KIRKLEES METROPOLITAN COUNCIL INVESTMENT & REGENERATION SERVICE

DELEGATED DECISION TO DETERMINE PLANNING APPLICATIONS

Reference No:	2026/62/90929/W
Site Address:	adj, 60, Cowrakes Road, Oakes, Huddersfield, HD3 3ST
Description:	Demolition of existing garages and erection of leisure annex with associated external alterations
Recommending Officer:	Nicole Helliwell

Officer Report

Ground Floor Plan
1 : 50

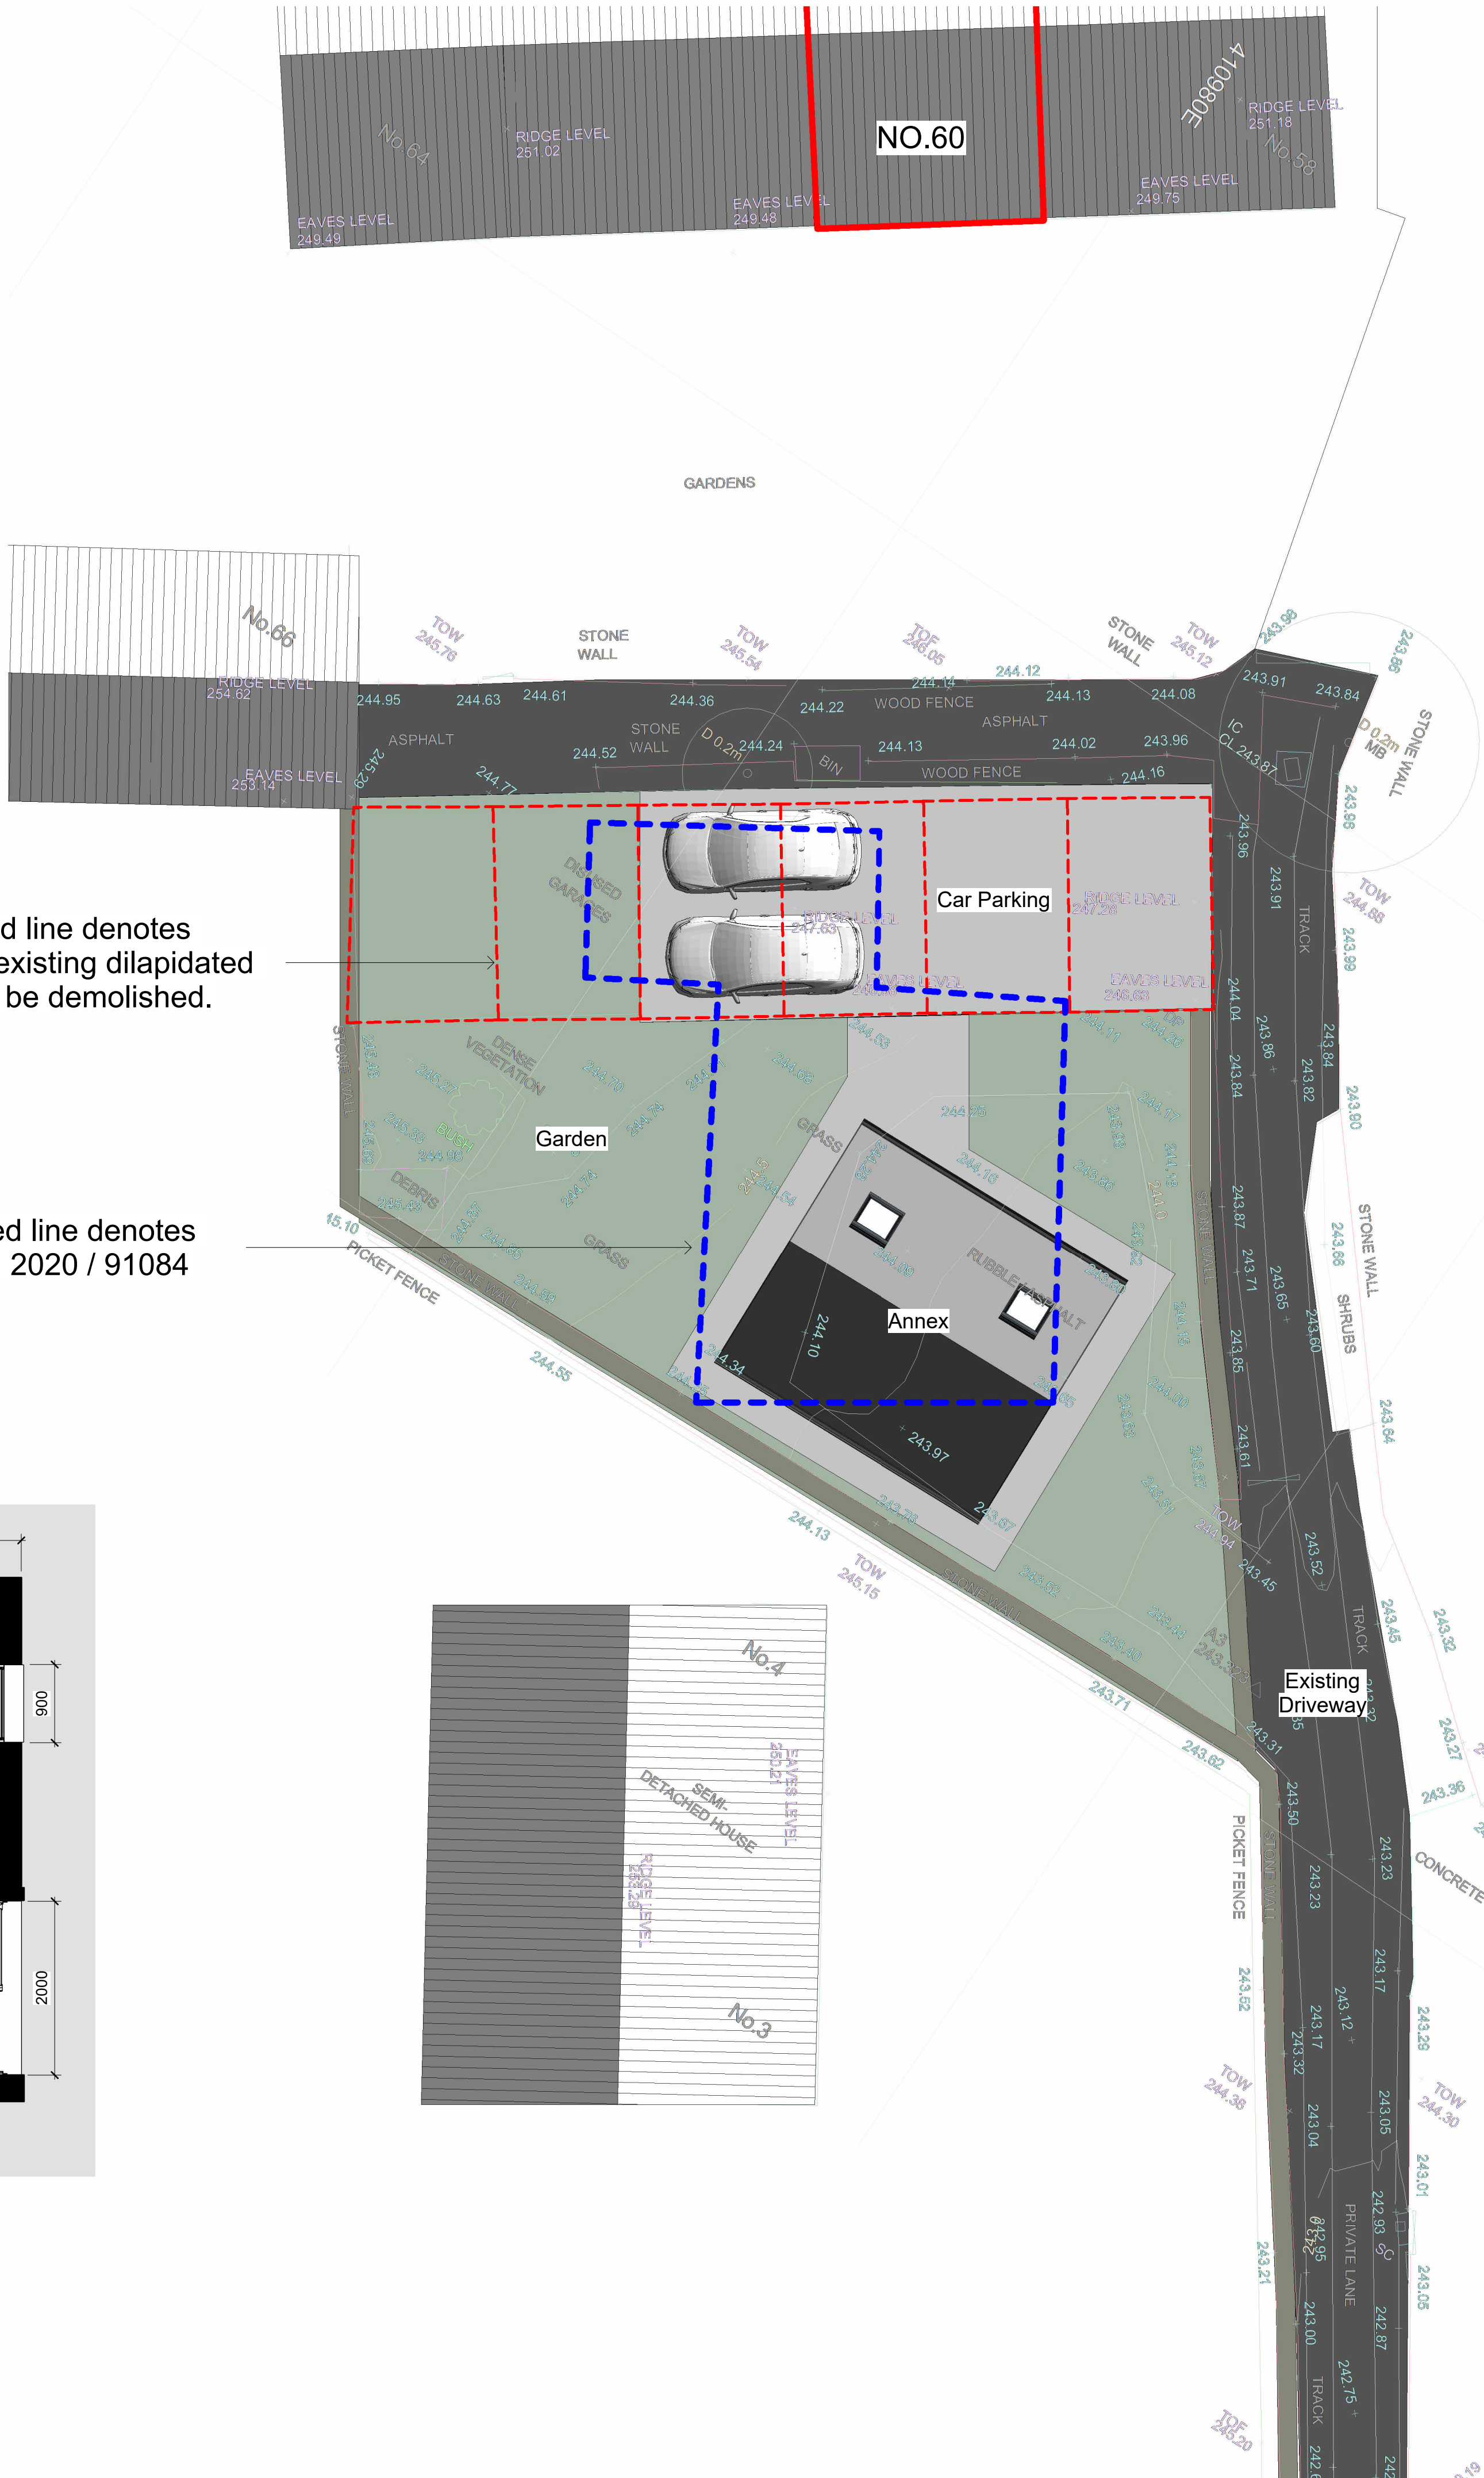
Amendments were received during the course of the application to address comments from KC Conservation and Design. Officers initially raised concerns regarding the curtilage listed stone wall which was to be removed as part of the application. However, revised drawings were received showing that this wall is to be retained which is acceptable.

- It concerns the proposed demolition of the front garden wall of number 60 in order to provide a car parking space. This would significantly detract from the uniform appearance of this short row all of which have a front garden terminated by a stone wall providing access to the footpath. I telephoned planning this morning to ask for the Listed Building team in relation to this part of the plan as shown in the drawing of the annex and proposed parking of cars. They said the call-back system would over run the end date for comments, Saturday 6th June, hence this email now.

Officer Response: *Revised drawings were received during the course of the application showing that the curtilage listed wall is to be retained.*
